Phone: 0300 123 6780
Email: developeras@lancashire.gov.uk
Your ref: 3/2025/0198
Our ref: 3/2025/0198/HDC/KW
Date: 02 June 2025

Location: Eaves House Farm Waddington Road West Bradford BB7 3JF
Proposal: Listed Building Consent and Planning Permission for the proposed conversion of Green Barn to create 1no dwelling with associated parking and amenity space. Conversion of Outbuilding 02 to form 2no double garages to serve the proposed barn conversion and Eaves House Farm. Partial Conversion of Outbuilding 01 to form new home office in relation to the existing listed farmhouse
Grid Ref: 373282 444679

6955 - B - P03F

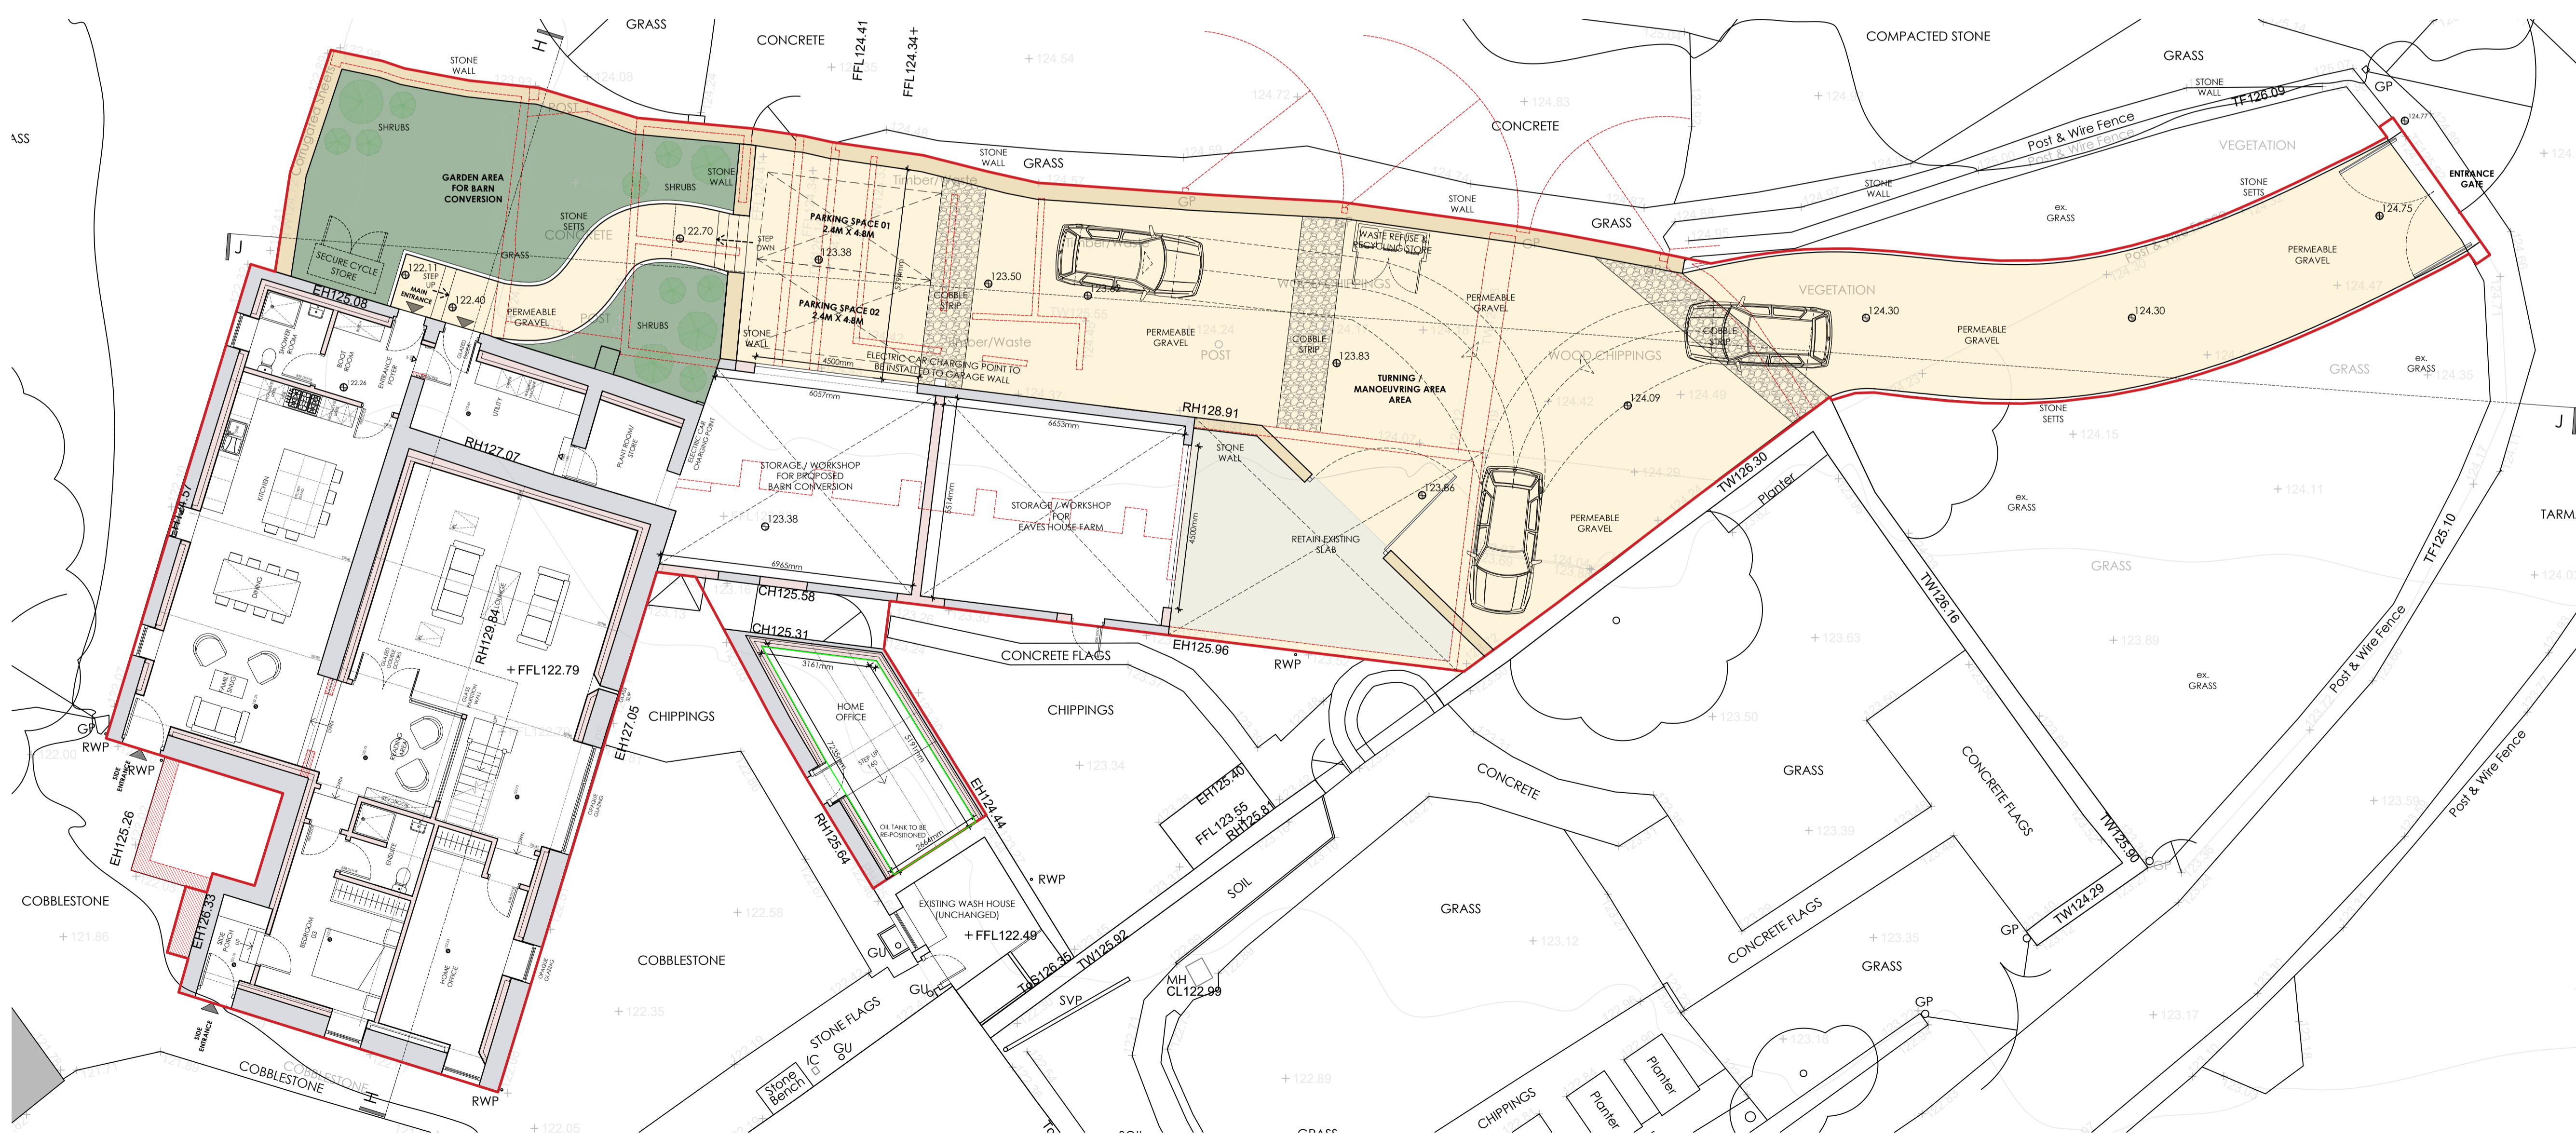
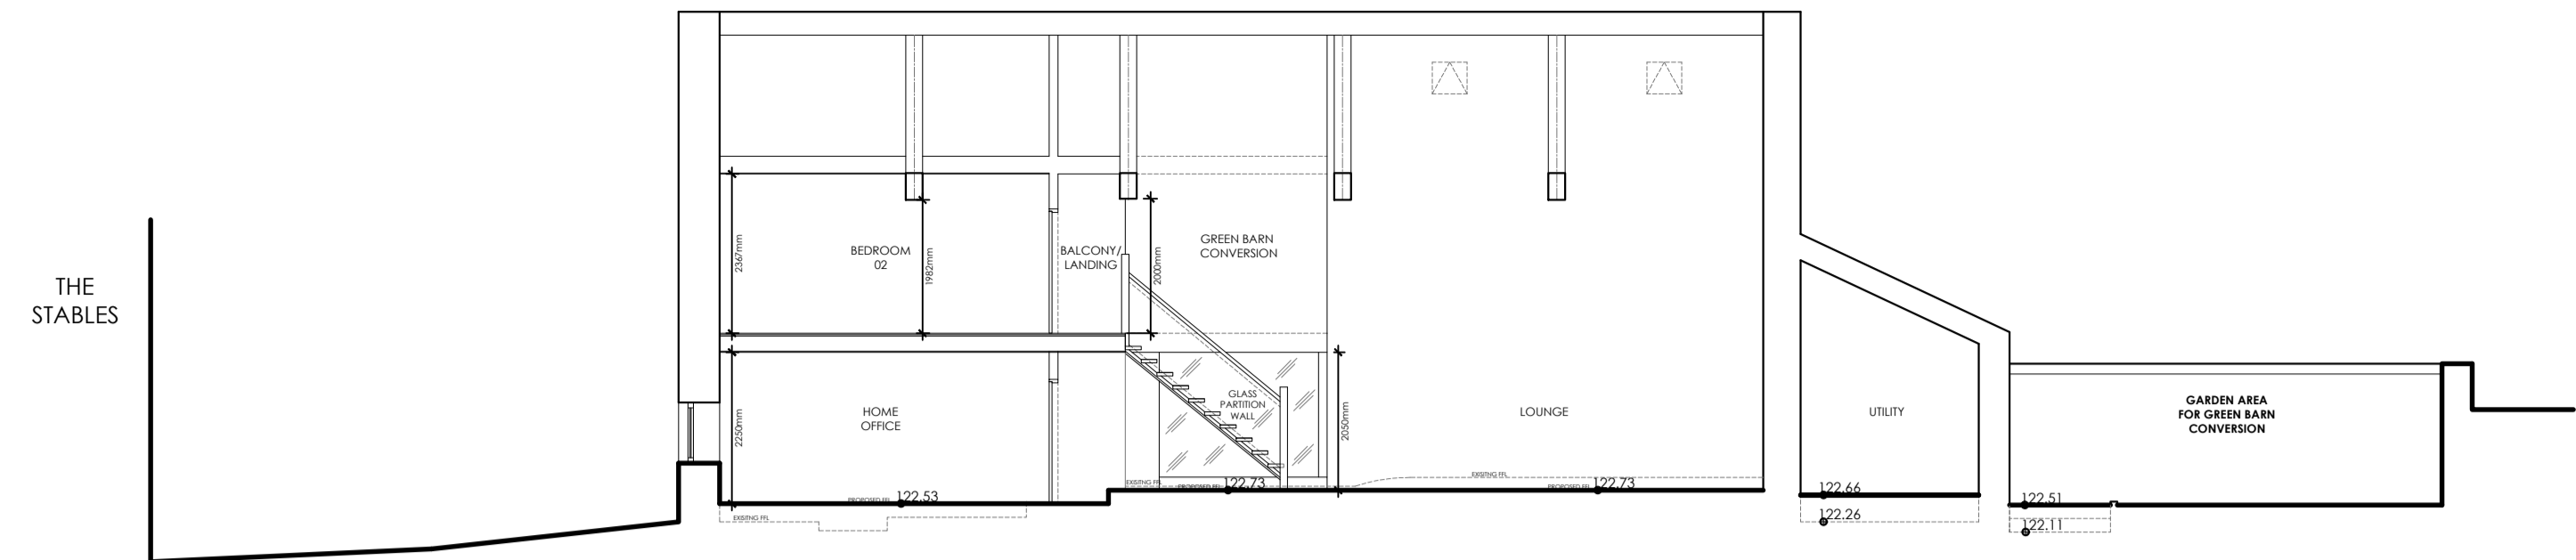
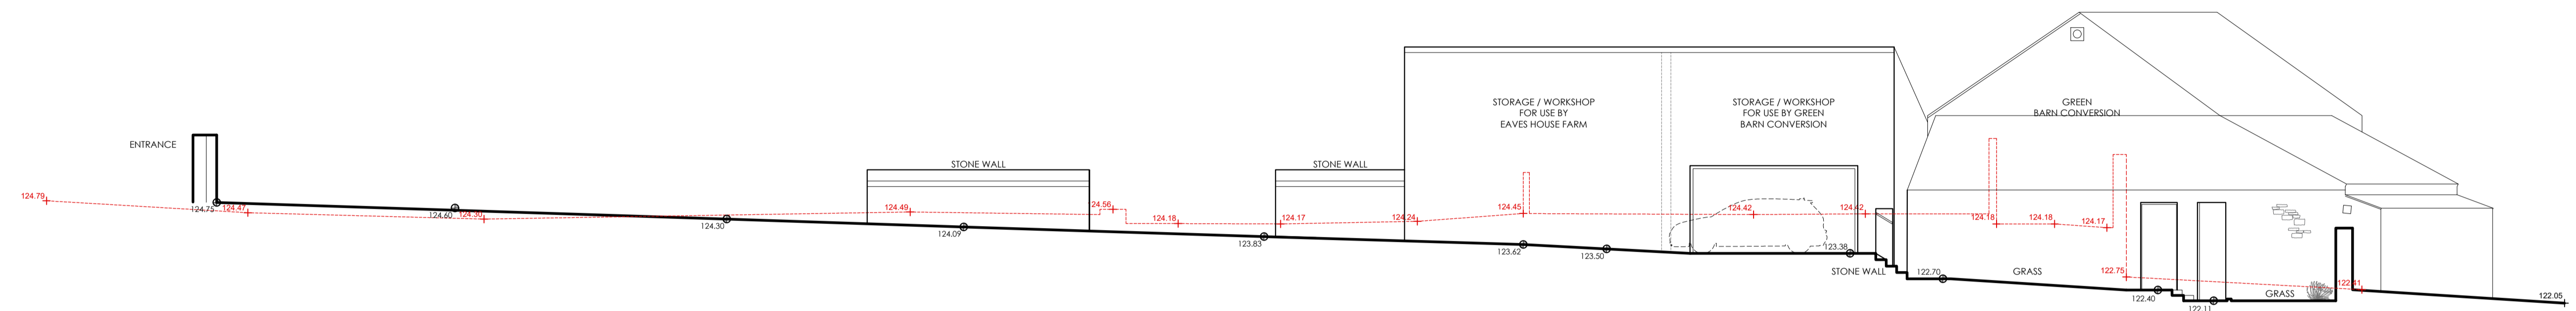
The LHA have reviewed drawing number 6955 B-P03C and note that the recommended minimum internal dimensions for a double garage size is 6m in length and 6m wide. However, the proposed garages are smaller than the recommended minimum internal dimension and as such they should not be counted as a parking space.

The proposed dwelling has 3 bedrooms, which requires 2 off-street parking spaces to be provided in line with the parking standards detailed in the Joint Lancashire Structure Plan. Given the single track nature of the private access track and that the access meets a C classified road vehicle within the site must be able to turn and leave in a forward gear.

The applicant has provided an amended site plan, drawing number 6955 B-P03C which shows off street parking provisions for 2 vehicles as well as turning provisions within the site. Additionally, parking can also be provided for vehicles associated with Eaves House should it be required.

1. The development hereby permitted shall not be occupied or brought into use until the car parking and turning areas shown on the approved plan(s) have been provided in full and are available for use. The car parking and turning areas shall thereafter be kept available for the parking and manoeuvring of vehicles at all times.
Reason: To ensure the provision of adequate car parking on site and in the interests of highway safety.
